## Re: Taco Bell- Site Plan amendment

Given the recent flurry of e-mails and several outstanding questions, I thought I would set out below the status of the review and clarify the engineering comments

CONCEPT PLAN

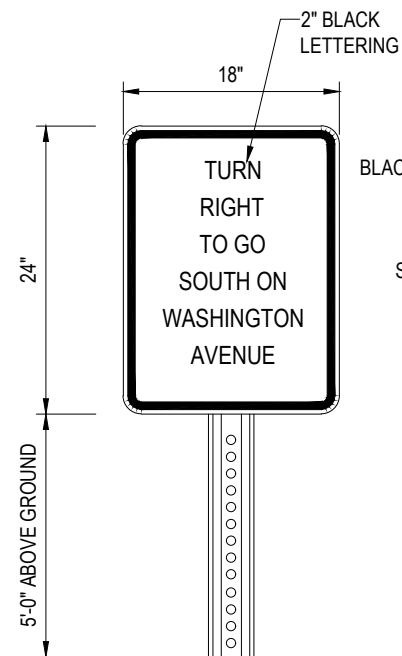
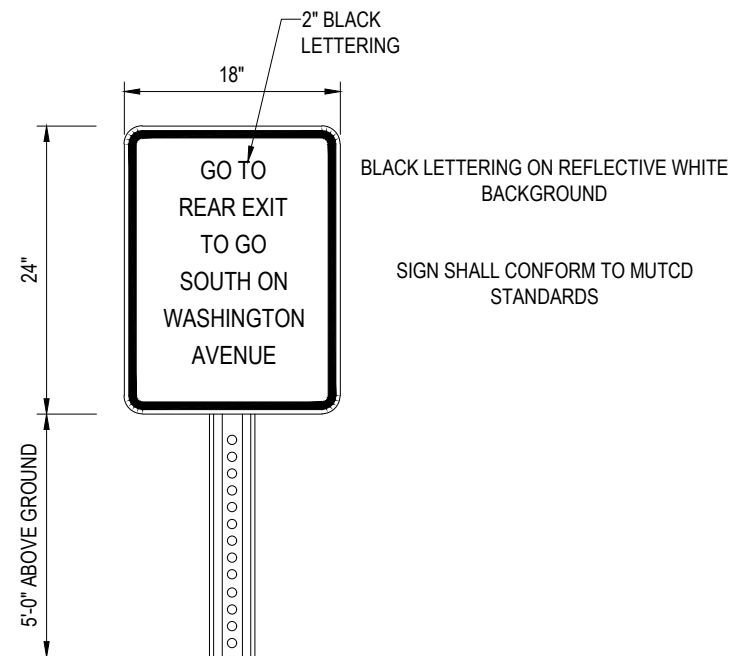
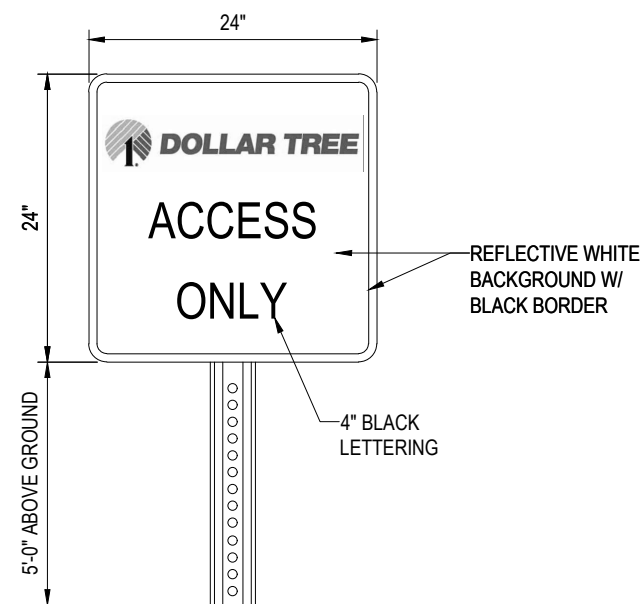
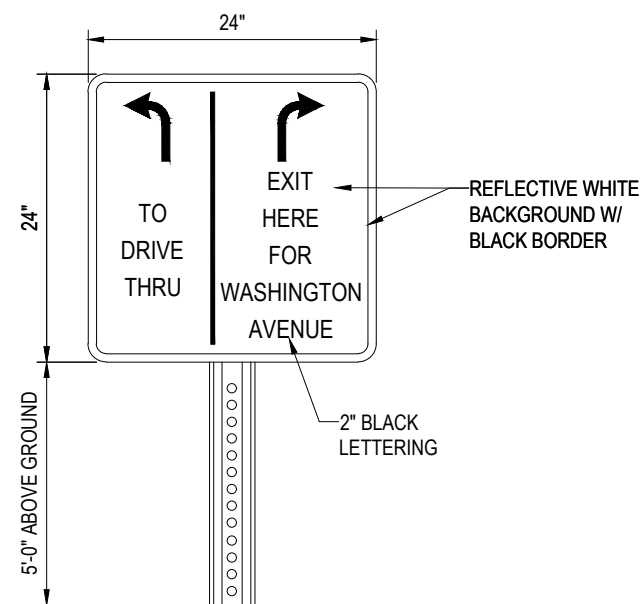
2. **Restrictions in turns in/out Washington Ave:** The Written Statement at the moment indicates that right turns into the site from Washington would be prohibited; however, there is no effective way to sign or mark this prohibition (thats why my engineers wanted the median if there was no rear exit). So there really is no restriction on that, and that reference should be removed to avoid confusion.

- Reviewers request an additional sign within the site saying something like "EXIT" or "EXIT HERE FOR WASHINGTON AVENUE" at the location about where the gate to the trash enclosure is currently shown, so that it is visible to cars coming around from the drive through who want to go south (the other sign where there is a choice between the exit and the drive through is too far around and not visible enough).
